Broadland District Council and South Norfolk Council Response to Examining Authority's Written Questions (ExQ1)

Deadline D2 (14th September 2021) (Extended 23rd September 2021)

HAZARD REF	BRIEF HAZARD DESCRIPTION
F01 F04	WORKING NEAR WATER WORKING ON TOP OF EMBANKMENT

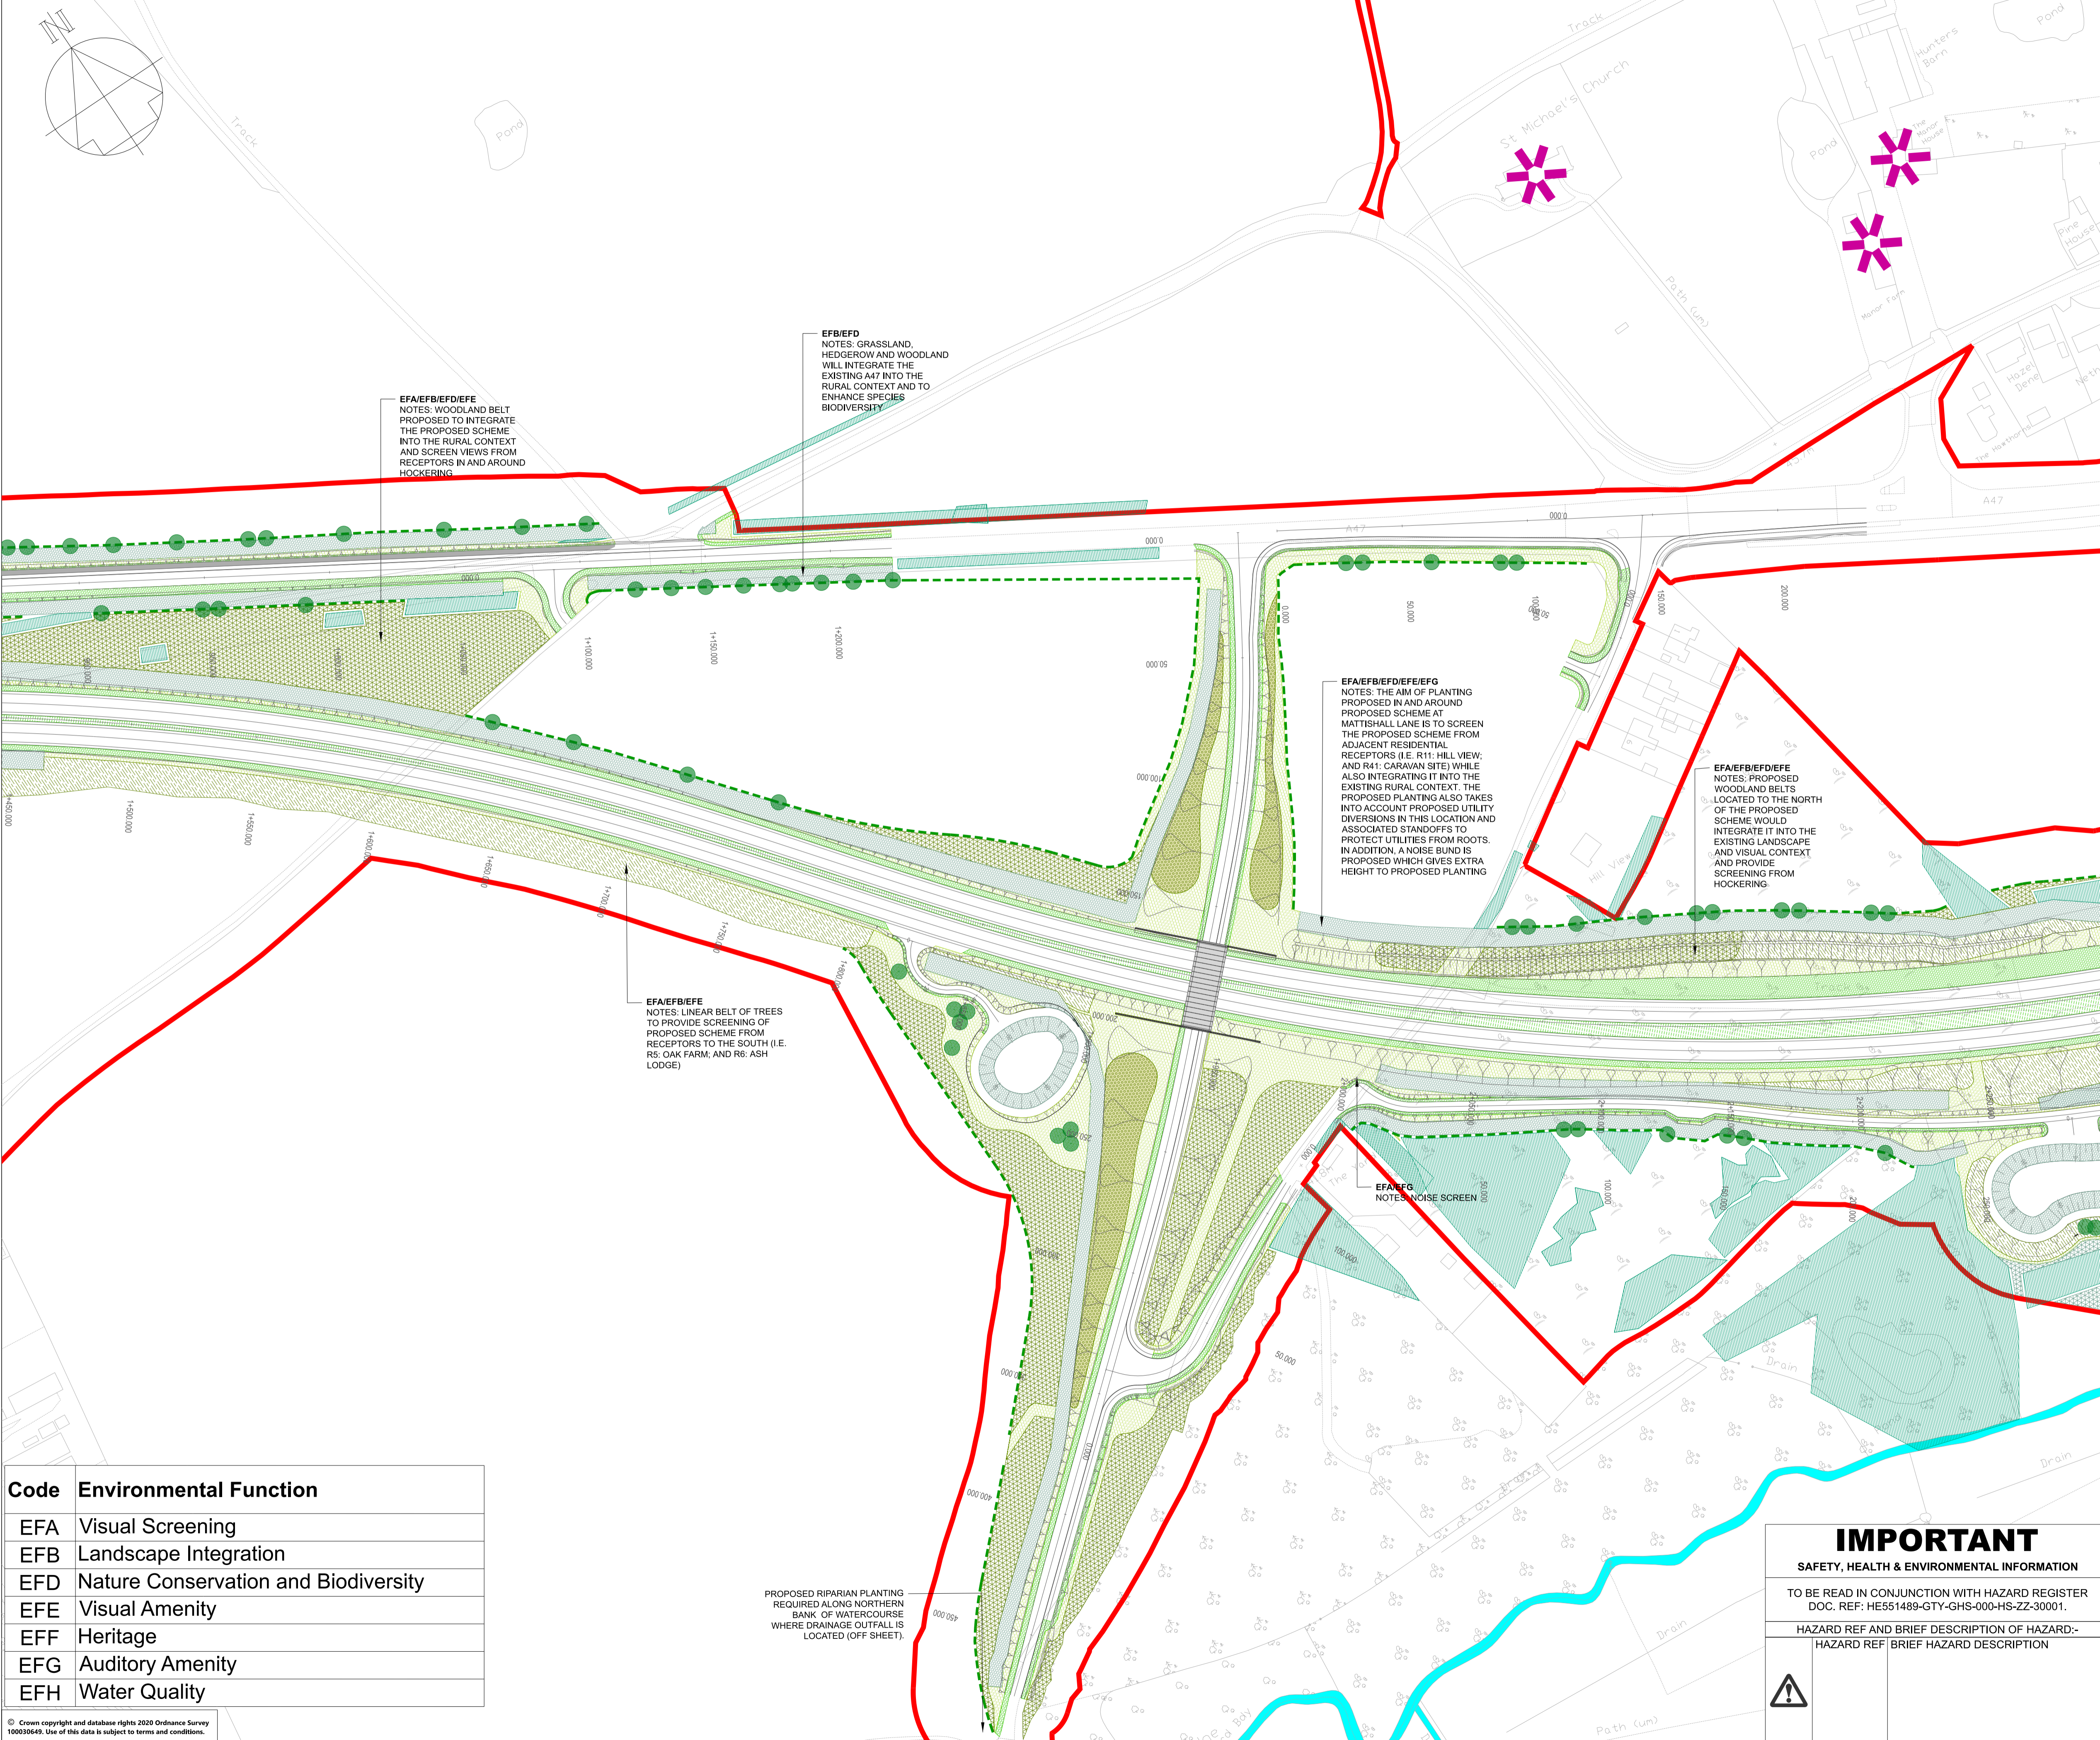
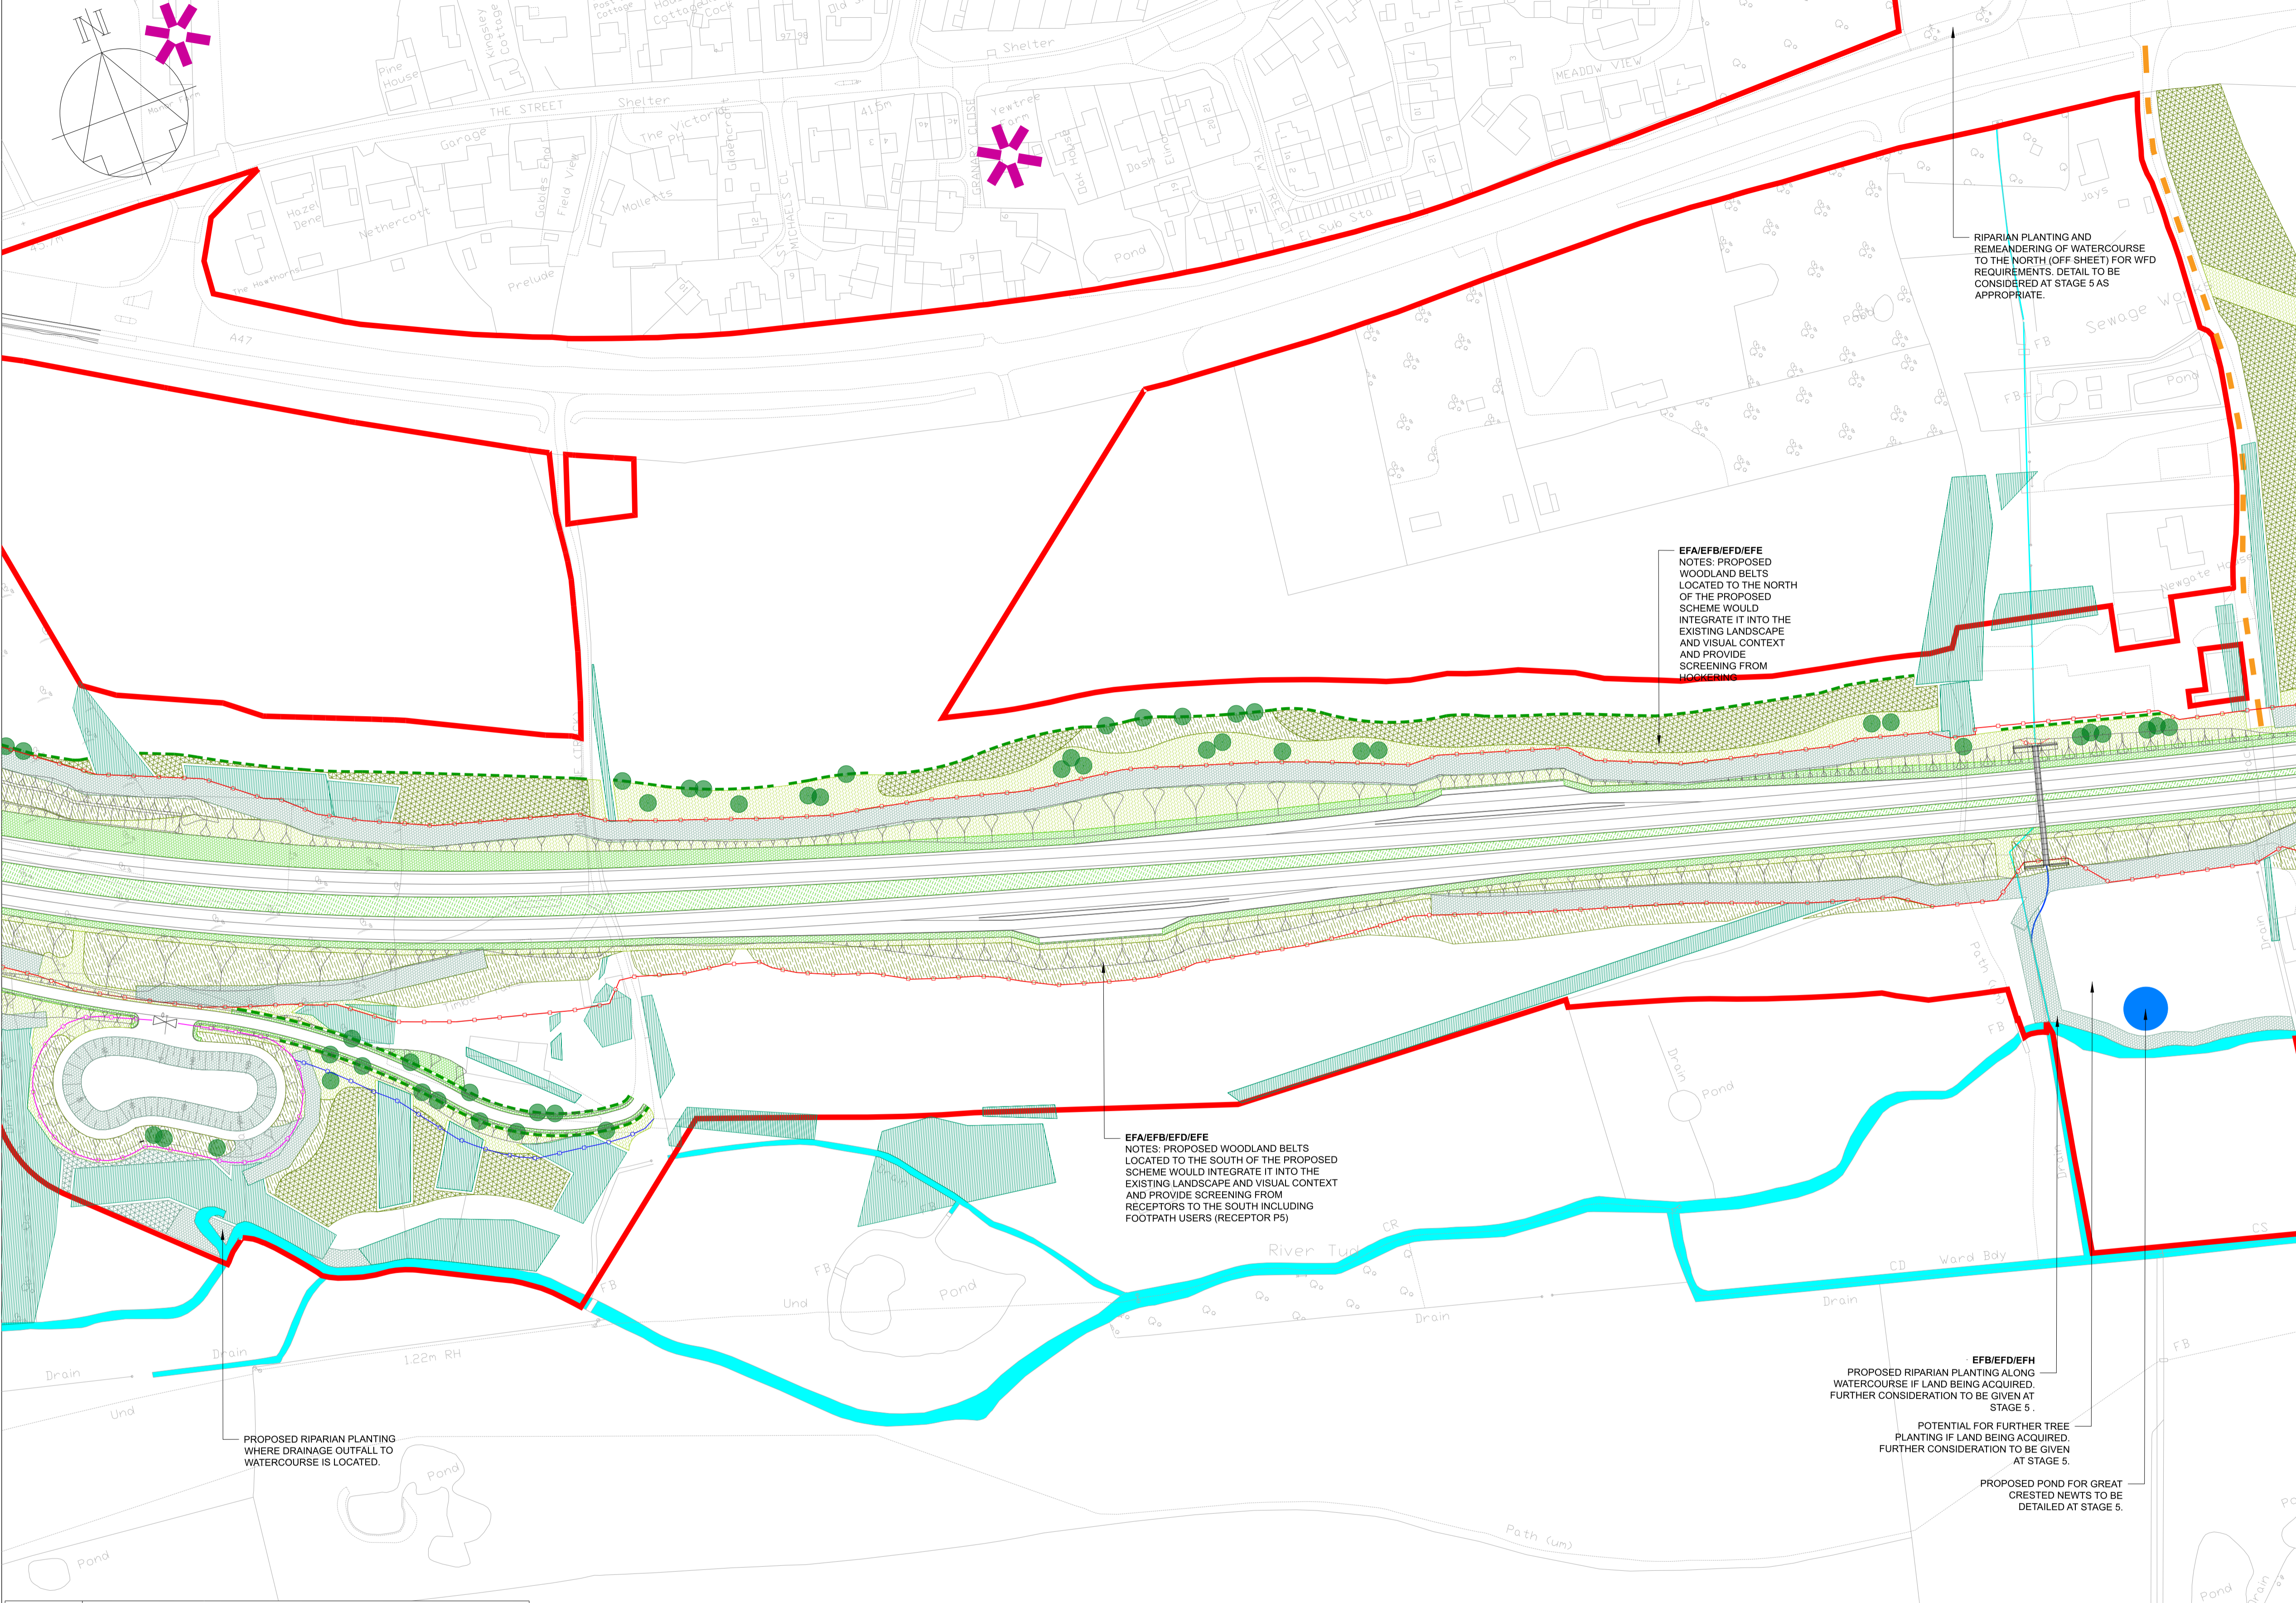
10.0.2	Are the parties satisfied with the Environmental Masterplan [APP-138] and the indicative proposals shown for the Proposed Development?	<p>These remarks were offered previously, but do not appear to have been considered:</p> <ul style="list-style-type: none"> • Reservations about the proposed formal approach to planting around the Eastern pedestrian/cycle bridge; this is not an urban area as the annotation suggests. • Will it be possible to view St Peter's Church Easton from the pedestrian/cycle crossing and/or its approach(es)? If not, is this desirable/possible? • What is the function of the spur of former Church Lane to the north of the proposed Easton pedestrian/cycle bridge? Is this necessary?
